MEMORANDUM

TO: Jean Fraser, Planner
FROM: David Senus, P.E. & Ashley Auger, E.I.T.
DATE: November 20, 2013
RE: Munjoy Heights, Level III Site Plan Application

Woodard & Curran has reviewed the Final Level III Site Plan Application for the proposed infill residential development located at 79 Walnut Street in Portland, Maine. The project consists of the demolition of two structures and the development of 29 townhouse style residences.

DRAWING NO.  
**C-20**

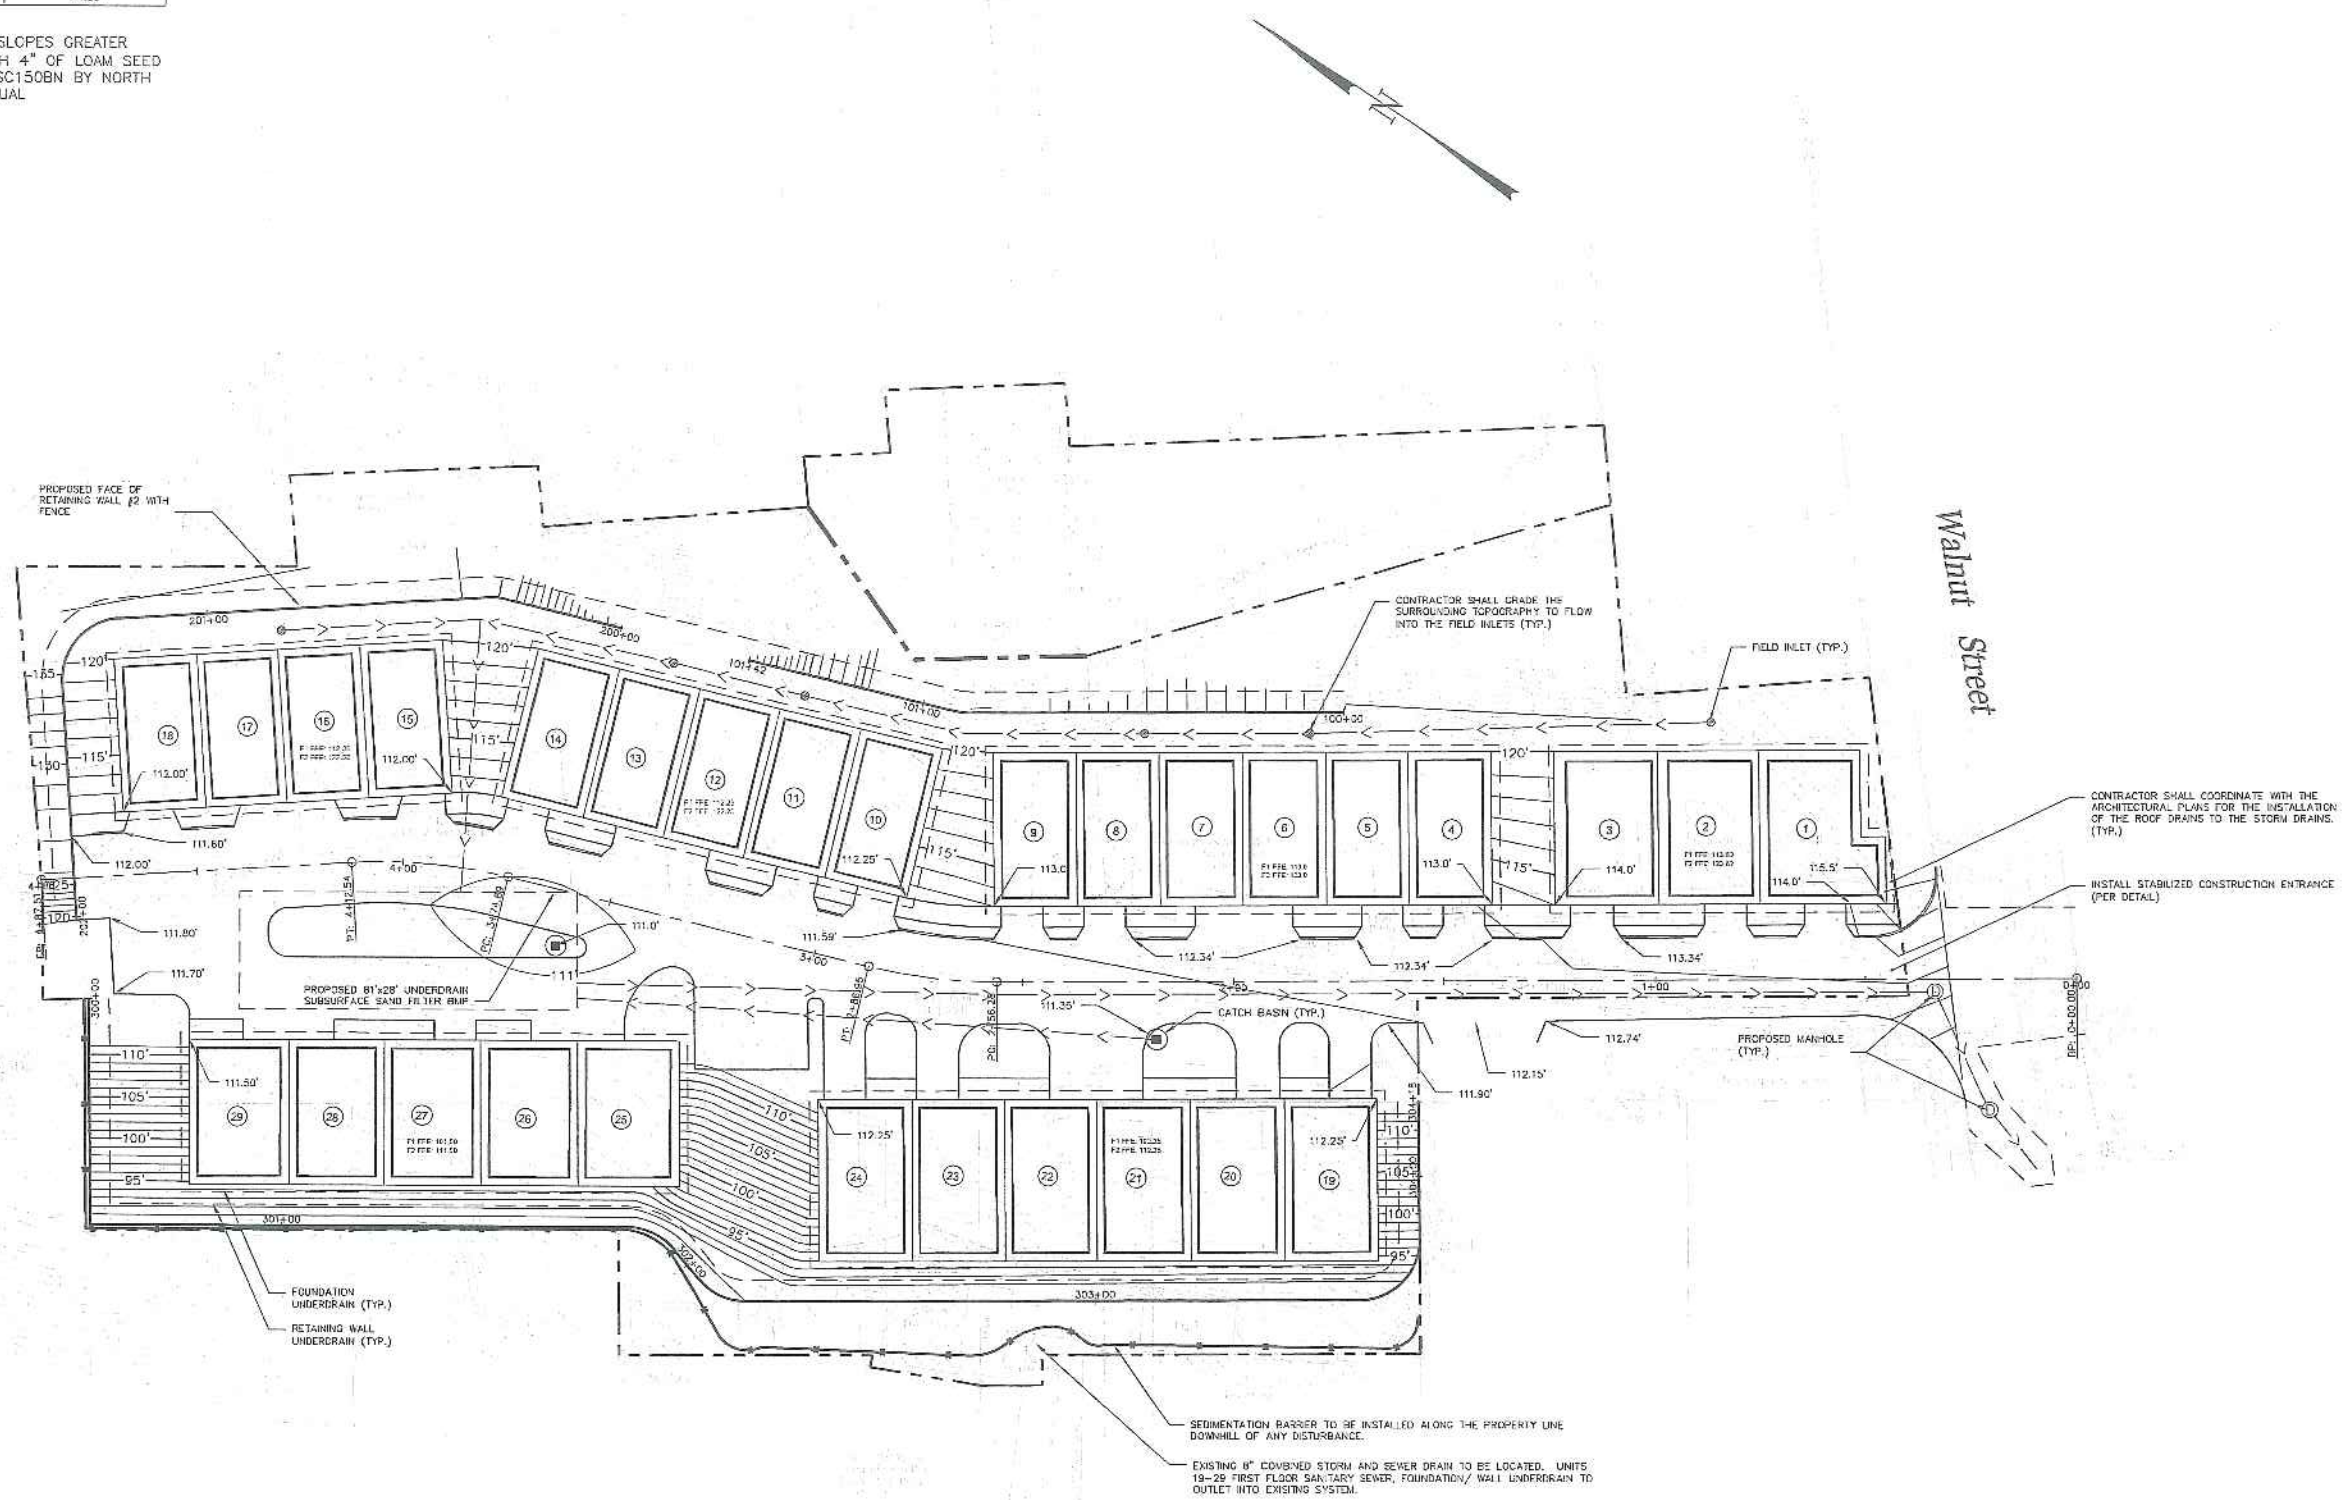
- 12) Sheet C-20 depicts a site sewer pipe below the trees located along the north edge of the woonef. We recommend shifting the utilities south to avoid root penetration and potential conflicts with the trees and the sewer system.

- 13) Sheet C-20, Note 5 states that the units have individual service connections to the utilities, but that these service connections are not shown for clarity. Utility connections to all buildings should be included on the plans.

- 14) Sheet C-20, Note 6 states that transformer pad locations will be determined by CMP prior to construction. The plan should indicate potential transformer pad locations (based on unit needs and setbacks); these can be labeled as approximate pending confirmation by CMP and future review/approval of the City.

- 15) Sheet C-20, the pavement sawcut proposed across Walnut Street should be squared off on the north and south side of the work, with a straight line across the road running curb to curb.

- 16) Sheet C-20, it is unclear how fire and domestic water services can be provided to Units 1,2 & 3 given the location of the fire meter pit relative to the building.

BRICK SIDEWALK WITH BITUMINOUS BASE DETAIL

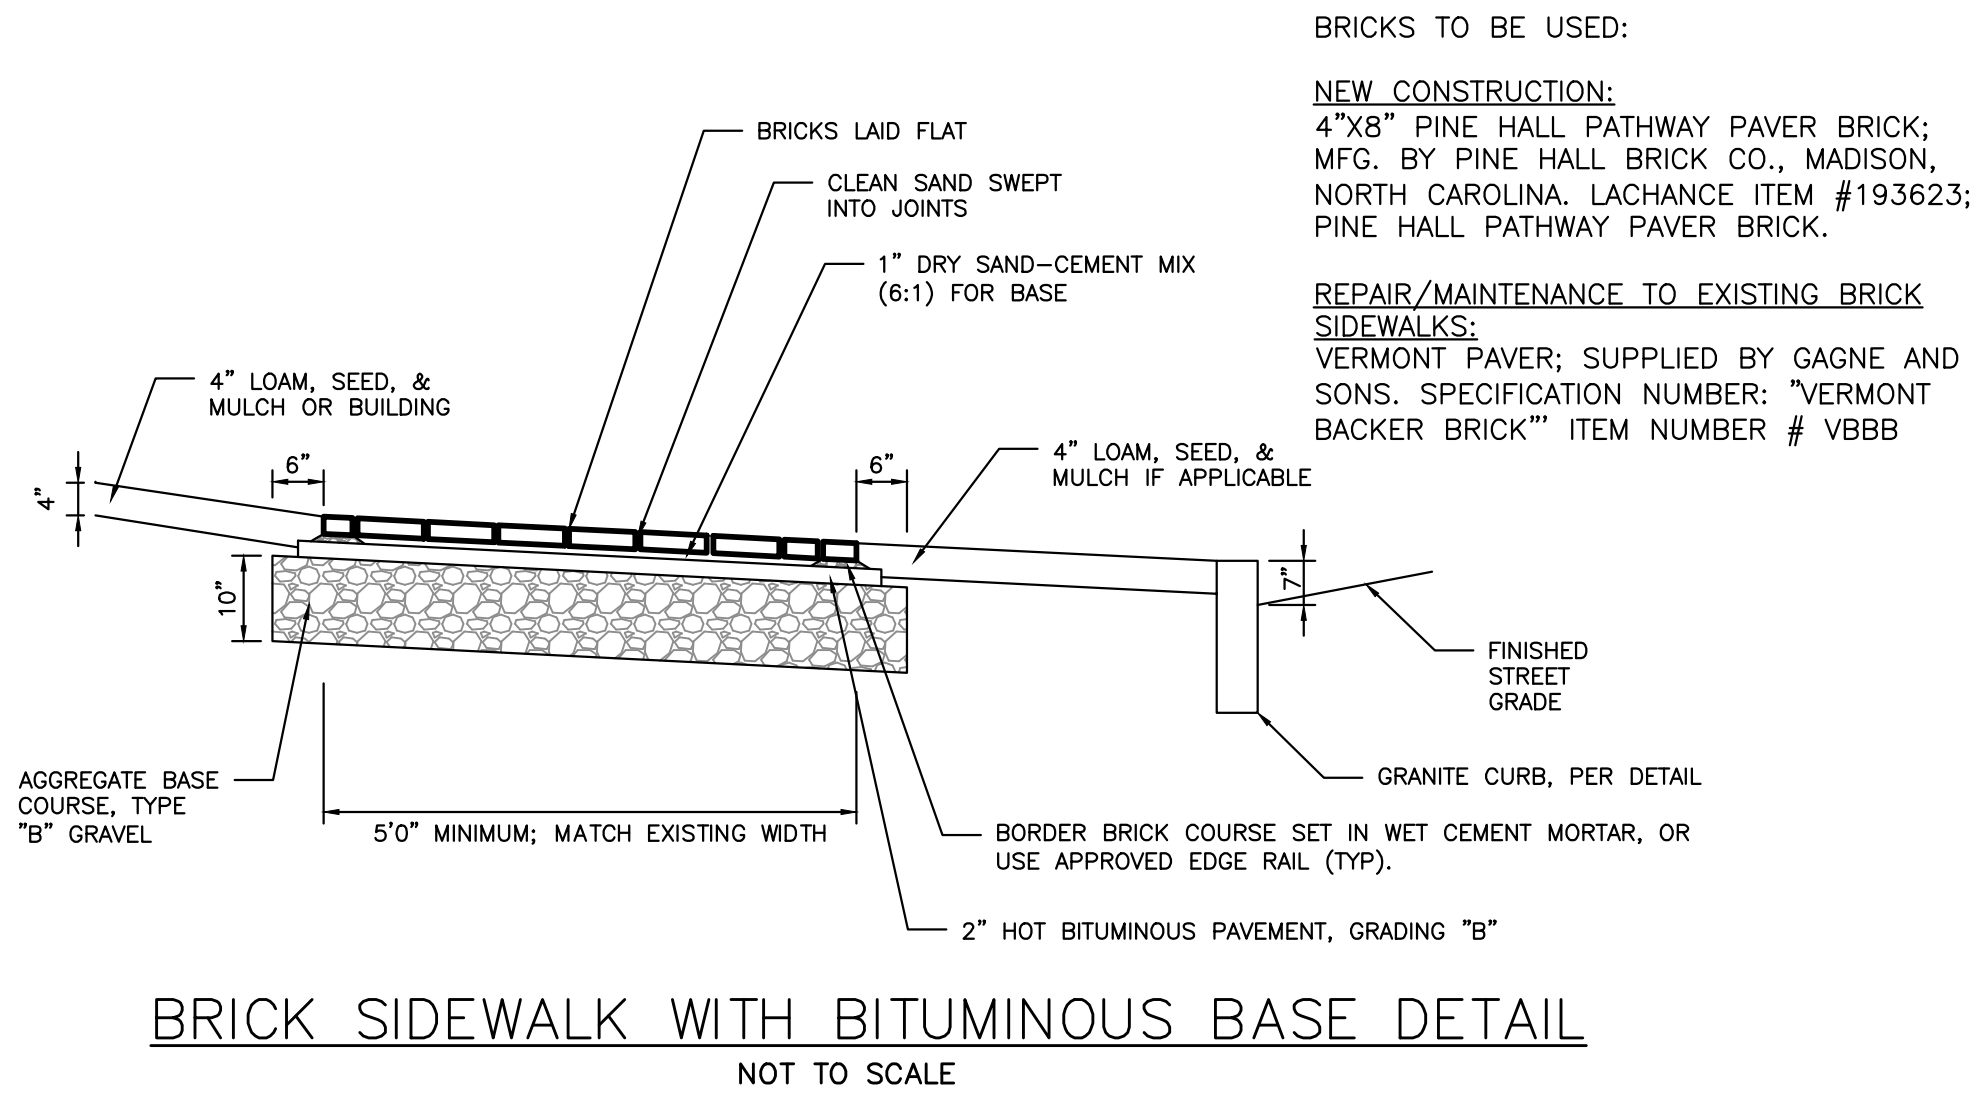
- a) Brick Sidewalk
 - b) Vertical Granite Curb & Tipdown
 - c) Pedestrian Ramp
 - d) Pipe trench
- 6) Future Submissions should include a detail for the proposed field inlet.
